## Comments on MICA SEPA Documents March 13, 2017

To: Mercer Island City Government Senior Planner Robin Proebsting.

Please accept my comments on the MICA SEPA documents dated March 13, 2017.

Figure 2. Approximate location and extent of Wetland A (yellow) with study area shown (red).

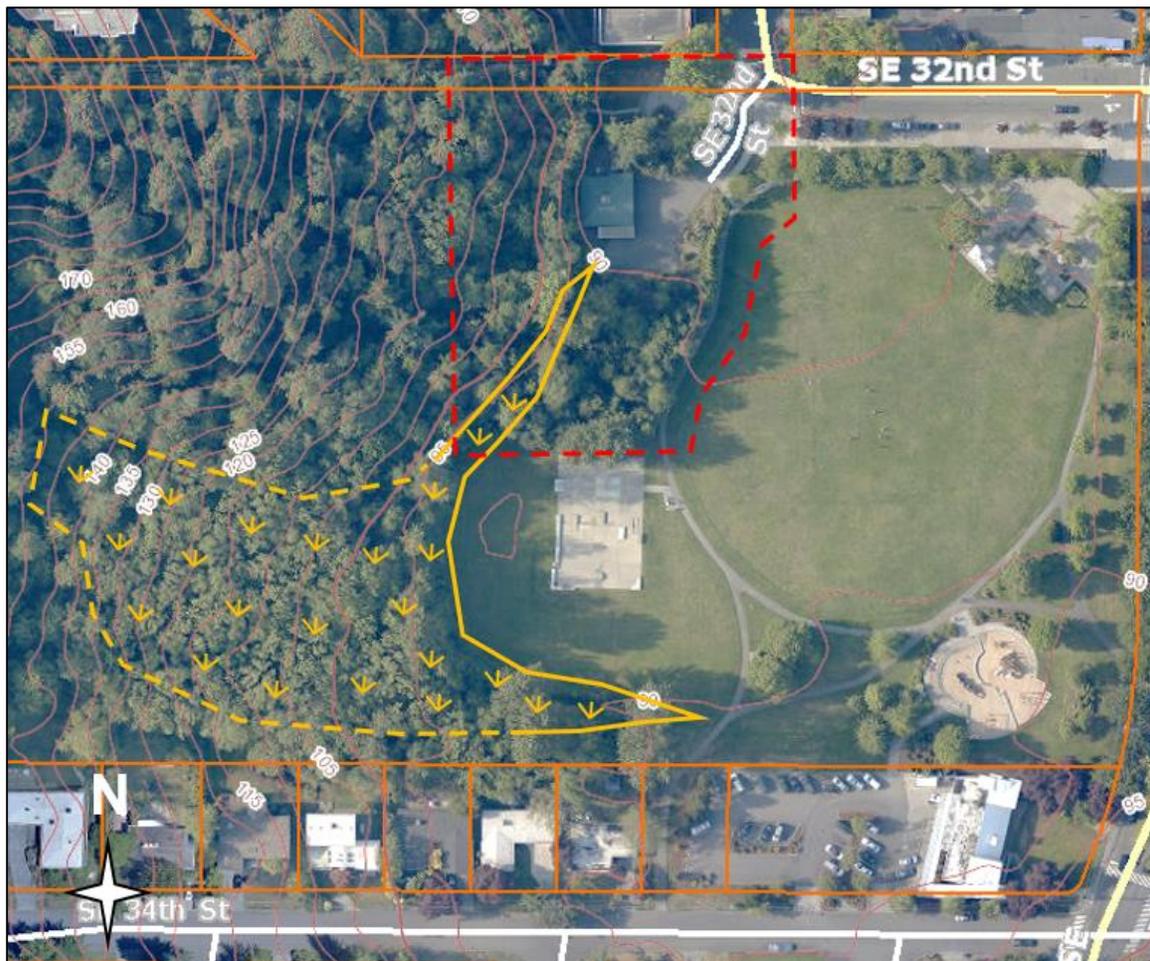
According to the city's storm utility max (Mercer Island GIS Portal) surface water from Wetland A flows both north & south into the city's storm water system. How much water is expected into the city's storm water system after the bio retention ponds are in place? What if the retention ponds are not sufficient? How will the water issue be resolved?

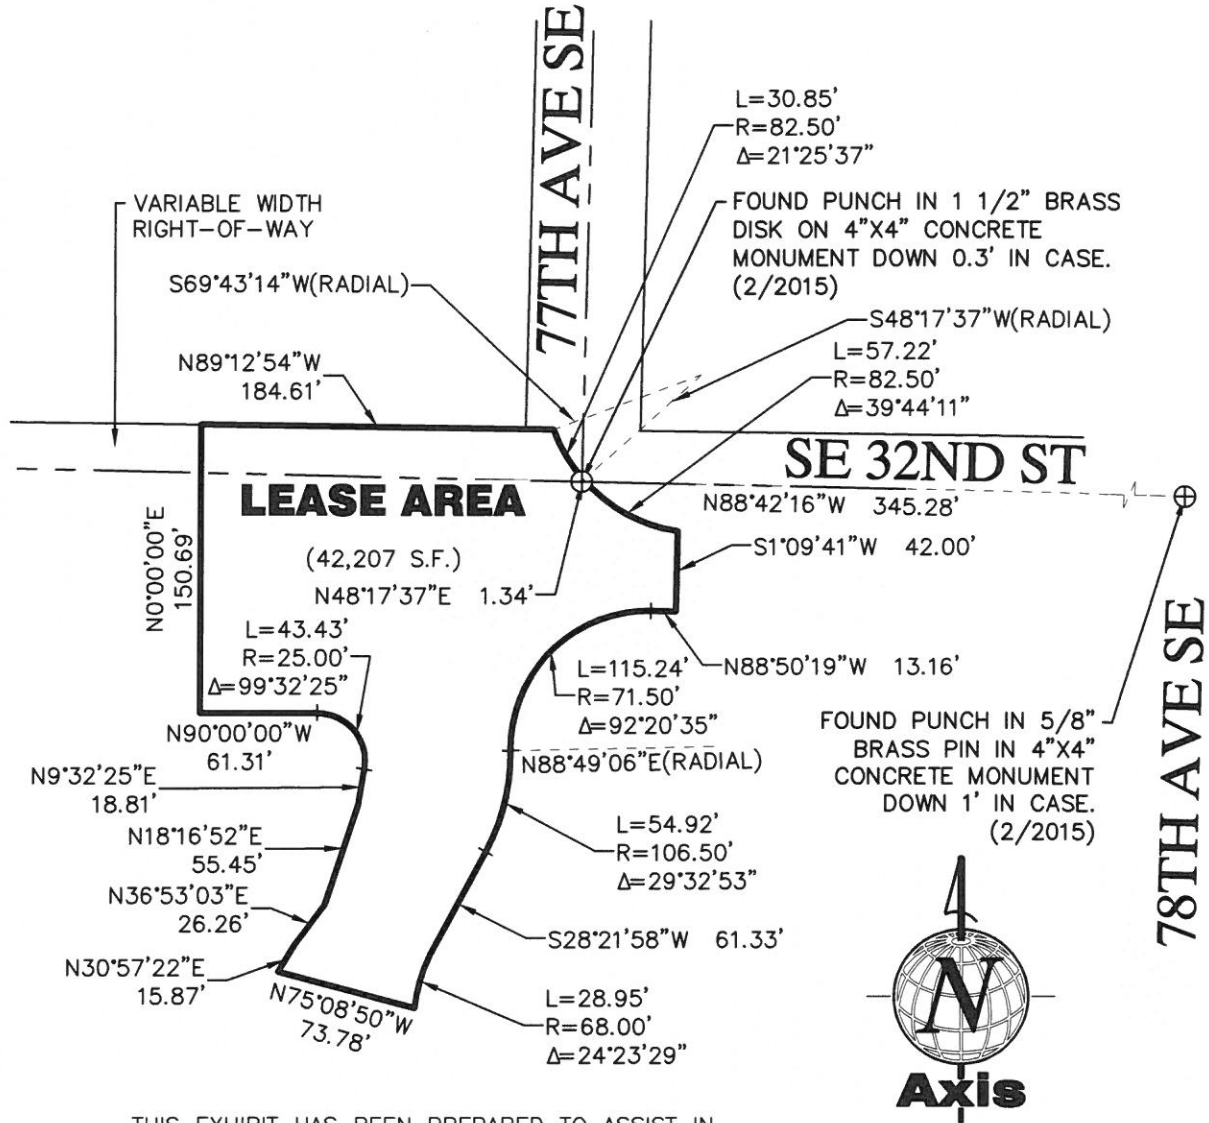
SE 32<sup>nd</sup> St is a public street and is not part of Mercerdale Park. Why would the city give up public street access when it may be needed to redirect traffic after the MI freeway exits and entrances are modified?

**MITIGATION PLAN
PREPARED FOR BRUCE LORIG
MERCERDALE PARK
77TH AVE SE & SE 32ND STREET (PARCEL # 1224049068)
MERCER ISLAND, WA 98040**

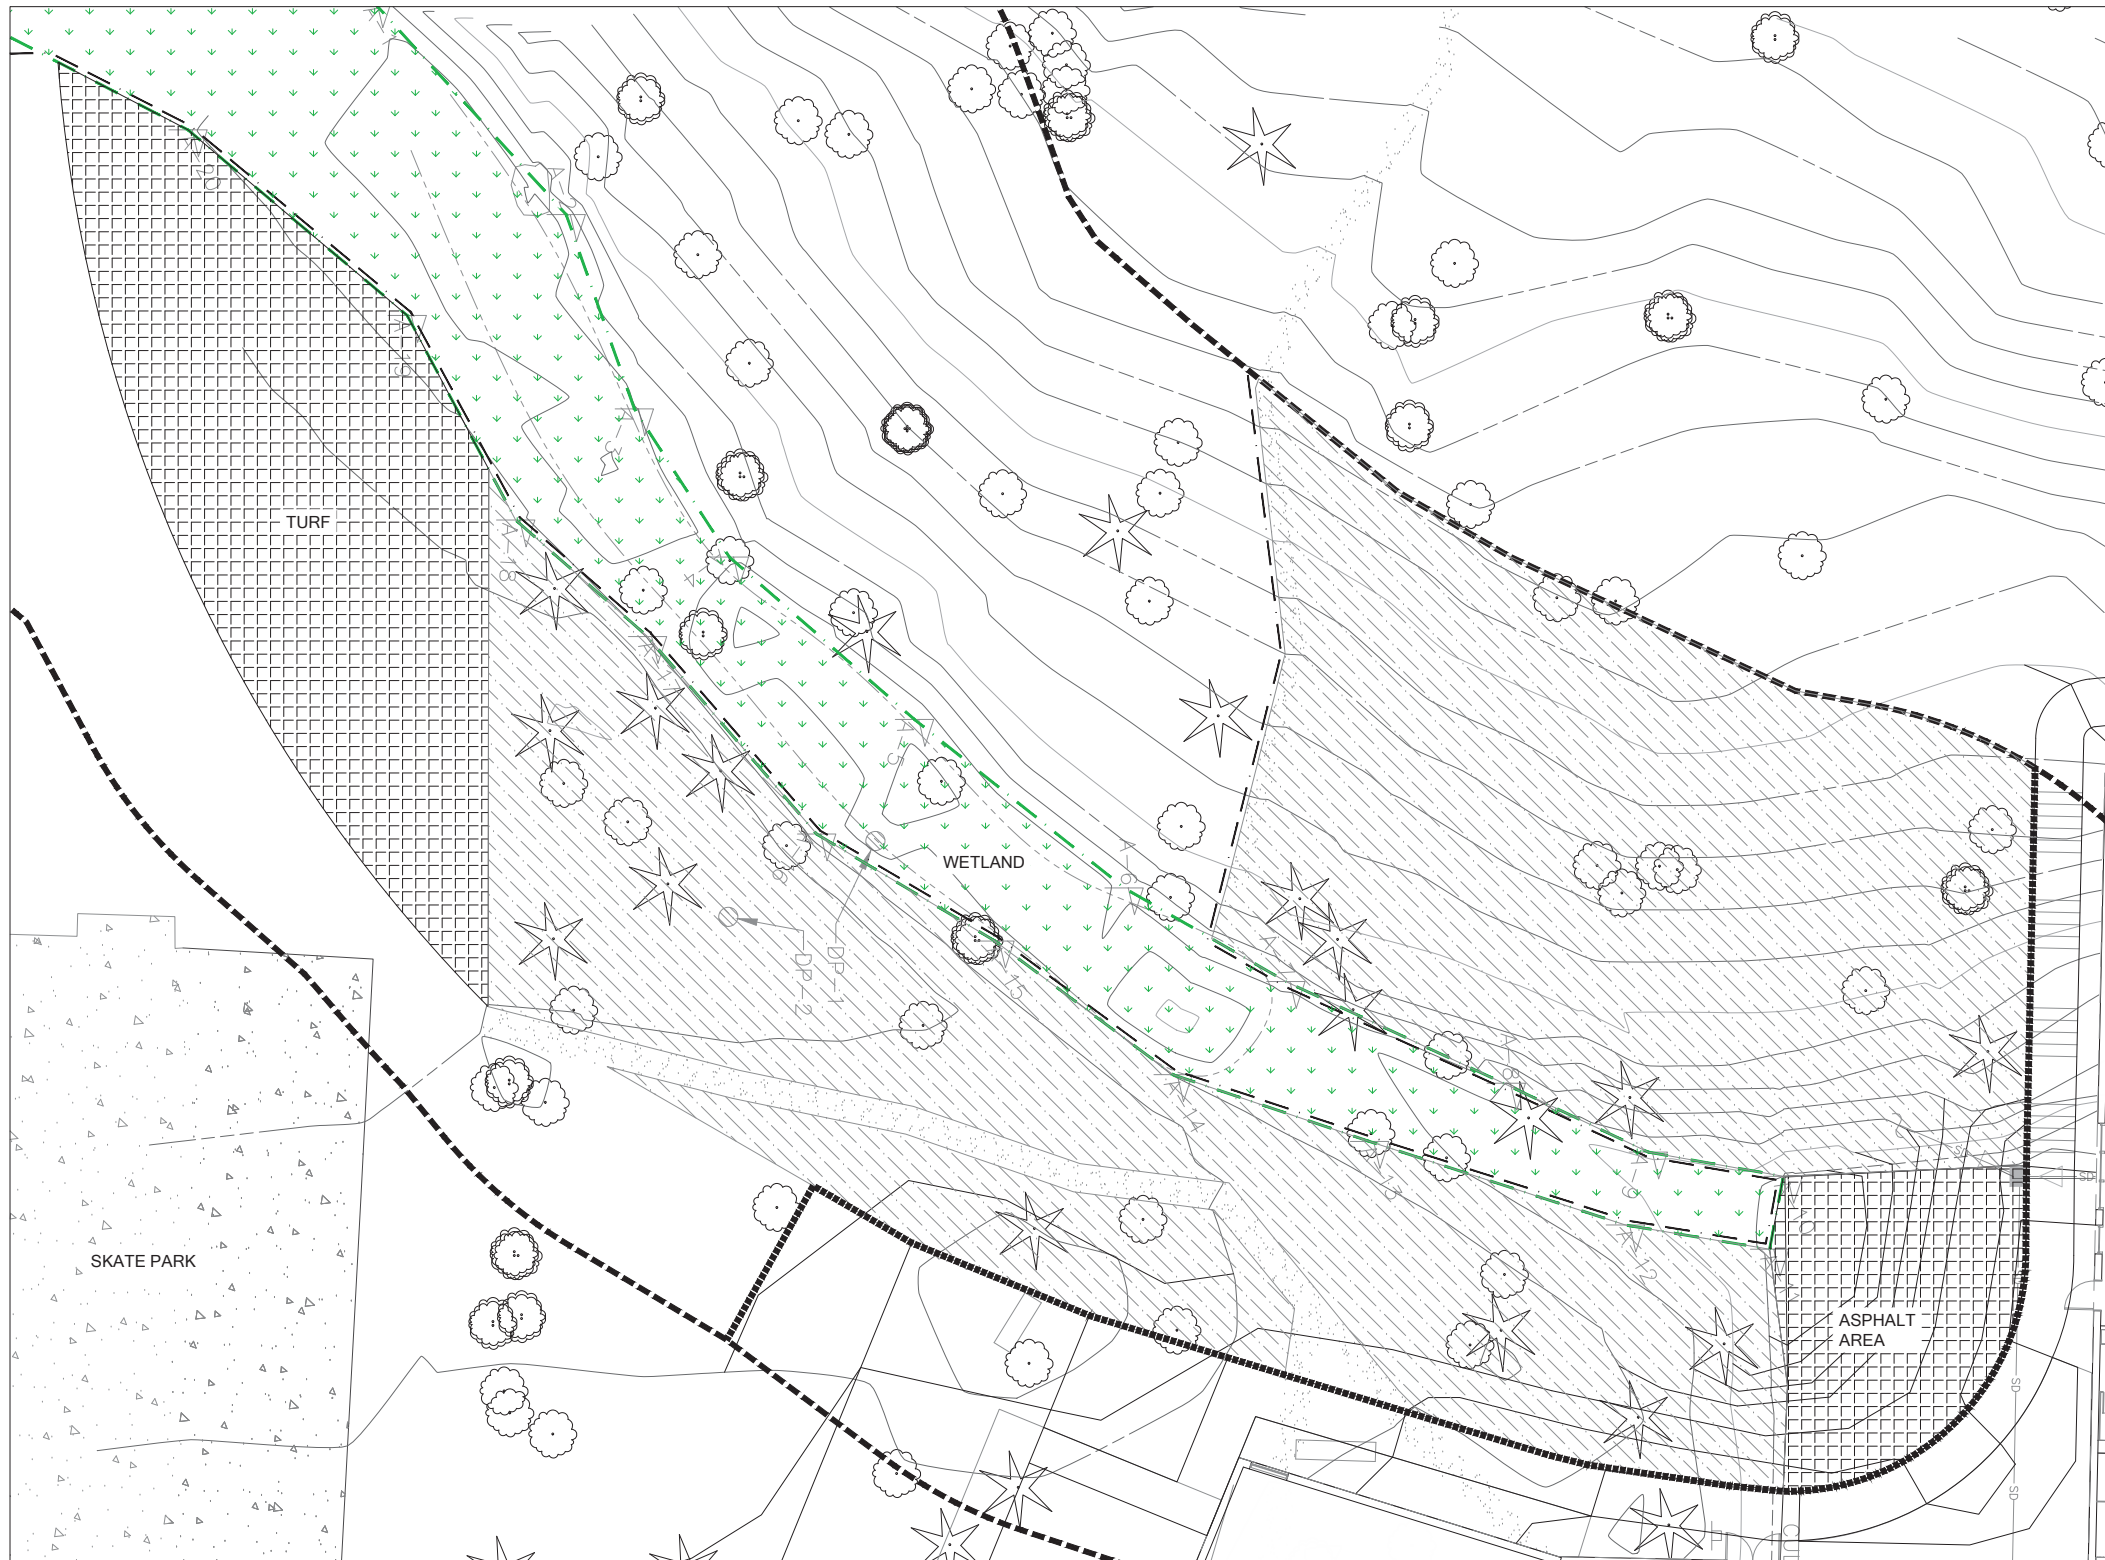
Decreasing the wetland buffers from 50 ft to 25 feet is mentioned. Which government agency will regulate the decision for decreasing the buffer? How will this decision be determined?
